KITTITAS COUNTY FIRE MARSHAL'S OFFICE

October 12, 2016

Re: Graaff (BL-16-00014)

GRAAFF/GIBB PROP.

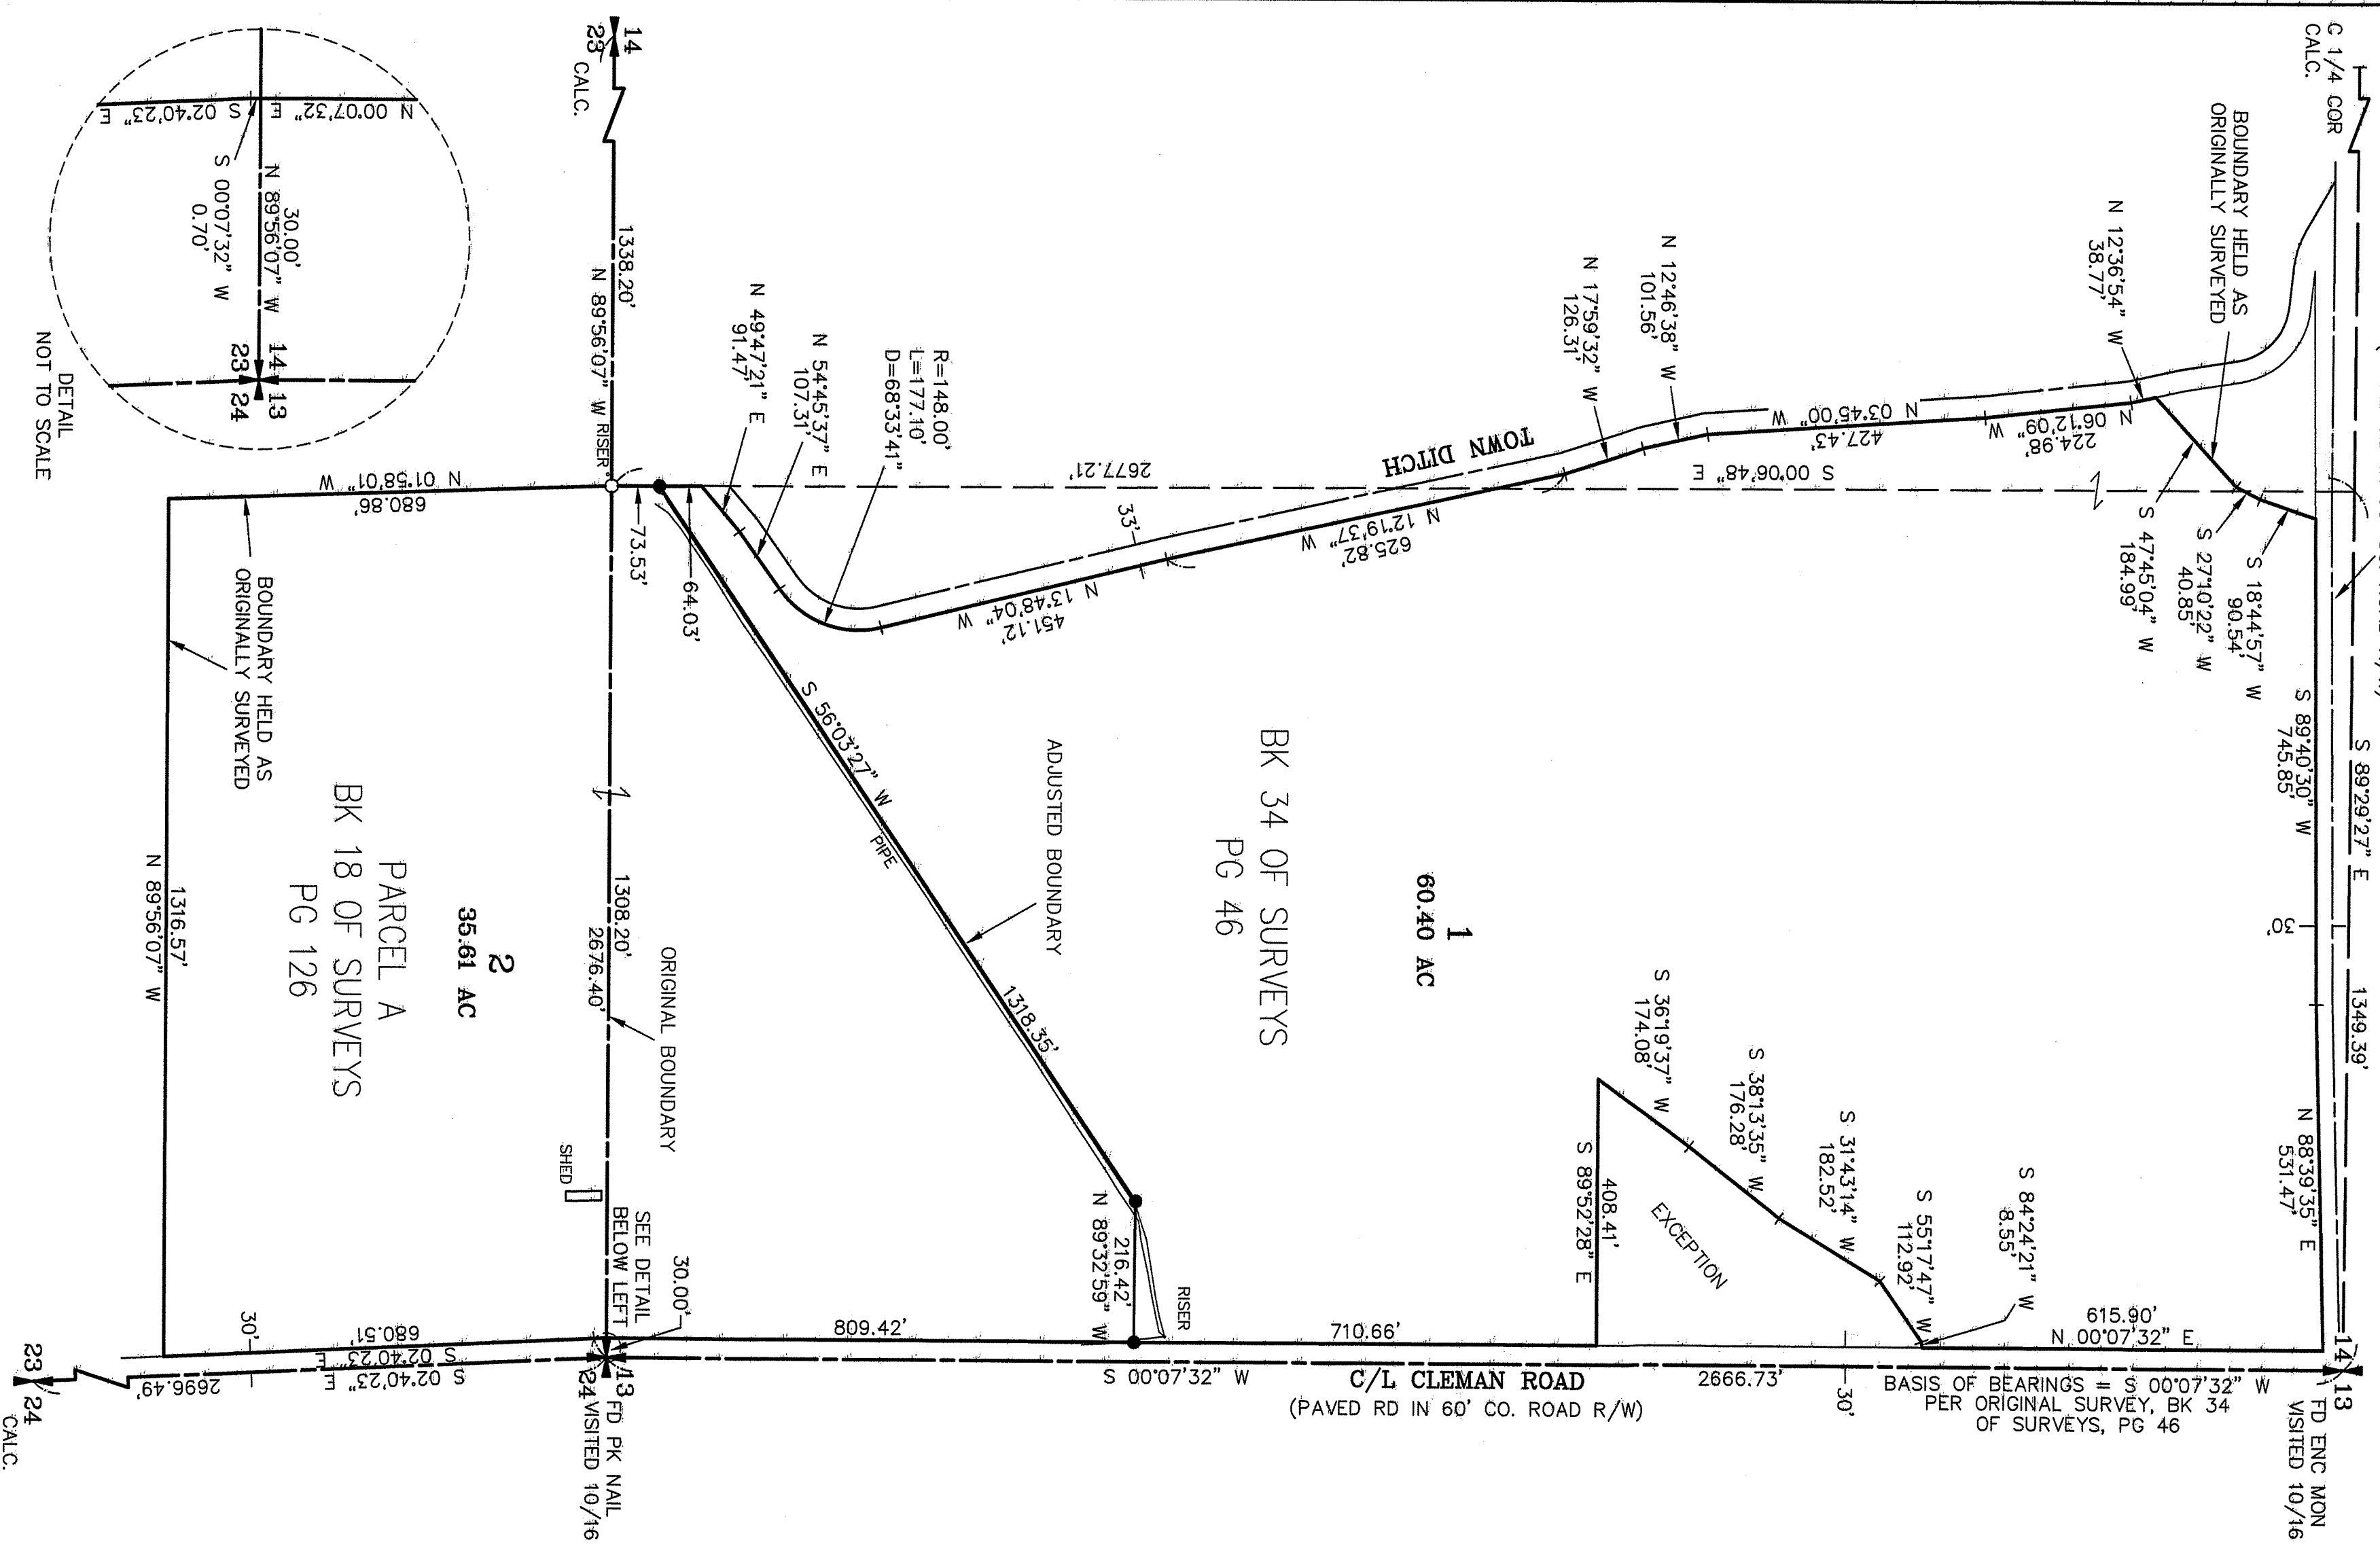
- Ensure that boundary line adjustments do not infringe upon existing structures, to include propane tanks, etc.
- Ensure adequate access for fire apparatus. Any driveways or access points created based off the new lot configurations shall comply with Kittitas County Code 20.02.030.
- All future development must comply with the International Fire Code.
